RE: Sydney Metro City and Southwest (Chatswood to Sydenham) (SSI 7400) EIS Modification 4

Thank you for the opportunity to comment on Modification 4 of the Environmental Impact Statement for the proposed Sydney Metro City and Southwest (Chatswood to Sydenham) project. We have reviewed the provided documentation and have identified that there are potential impacts to Sydney Water assets by the proposed modification.

Figure 21-1 Surface water catchments and watercourses

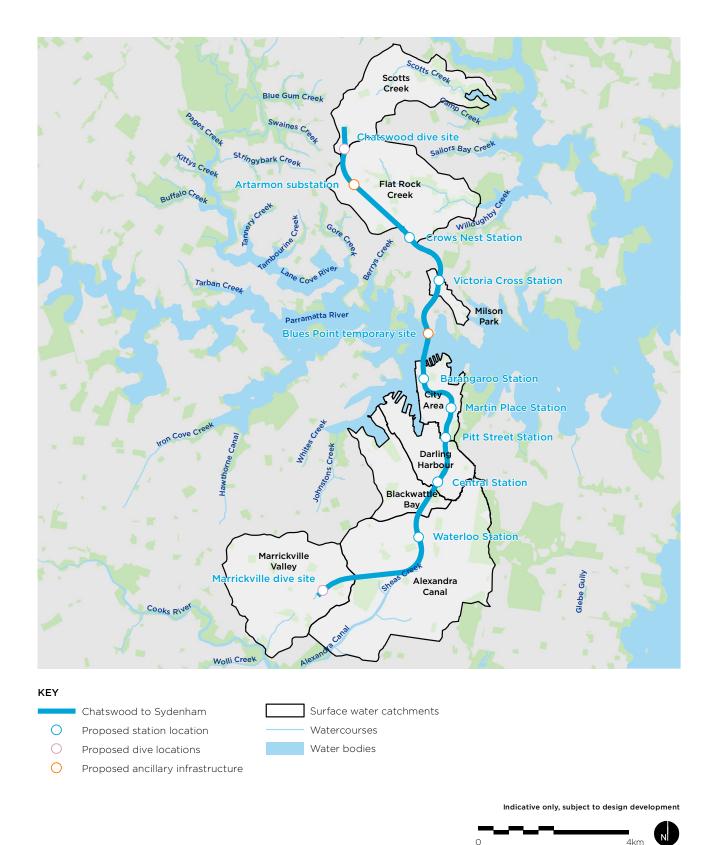
Sydney Water has been actively engaged with the Sydney Metro project in respect of the new location for the train stabling yard, which is within a low-lying flood prone area. The construction of the stabling yards at this location has the potential to increase the stormwater flows that are being diverted into Sydney Water's Sydenham Pit. To resolve this, Sydney Water will be required to pump out higher volumes from the pit into the Eastern Channel. This raises two key issues for Sydney Water and the Council in respect of stormwater management for the surrounding area, including:

- Possible reduction in the existing stormwater network capacity. The Sydenham Pit is currently the only mitigation against storm water flooding in the area. Increased flow into the pit may also reduce capacity in the stormwater network and limit the ability to add further flows from surrounding urban development.
- An increase to the pump out rate required from the Sydenham Pit will require the pump station to be upgraded to ensure higher reliability and reduce potential for flooding if the pit fills in a downpour.

The existing Sydenham Pit was built in 1935 and while some parts of the walls and floors have been repaired it is likely that the proposal to modify the pit will raise significant structural issues which will need to be addressed. Additionally, the pit in its current location is not publicly accessible. Providing pedestrian access would require consideration of the future cleaning and maintenance requirements to ensure the pit provides visual amenity for the public traversing the area. Consideration also needs to be given to future proofing the stormwater culverts leading into the pit as the construction above them will prevent future changes.

Figure 21-3 Marrickville dive site - change in flood level as a result of the project in the 100-year average recurrence interval event

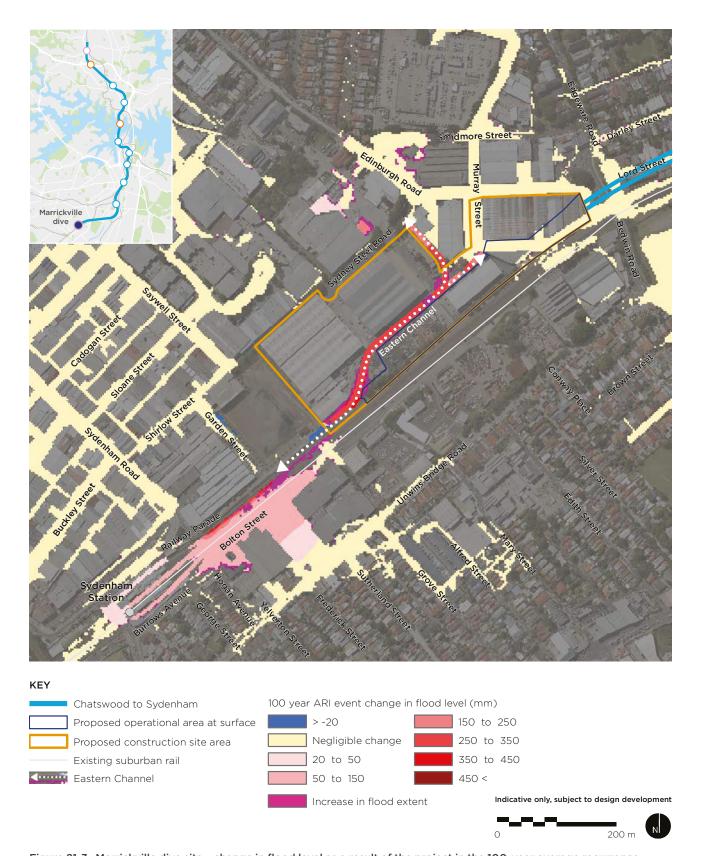
As the works around the stabling yards and the Sydenham Pit are being conducted by two separate contractors (TSE and SSJ) care needs to be taken to ensure that works are congruent and coordinated. Staging of the works will also need to be carefully considered to ensure that there is no increased flooding risk while works are being undertaken. The

stormwater network will be required to be fully operational at all times and as such access to Sydney Water assets will need to be maintained during construction and subsequent operations of the Metro.
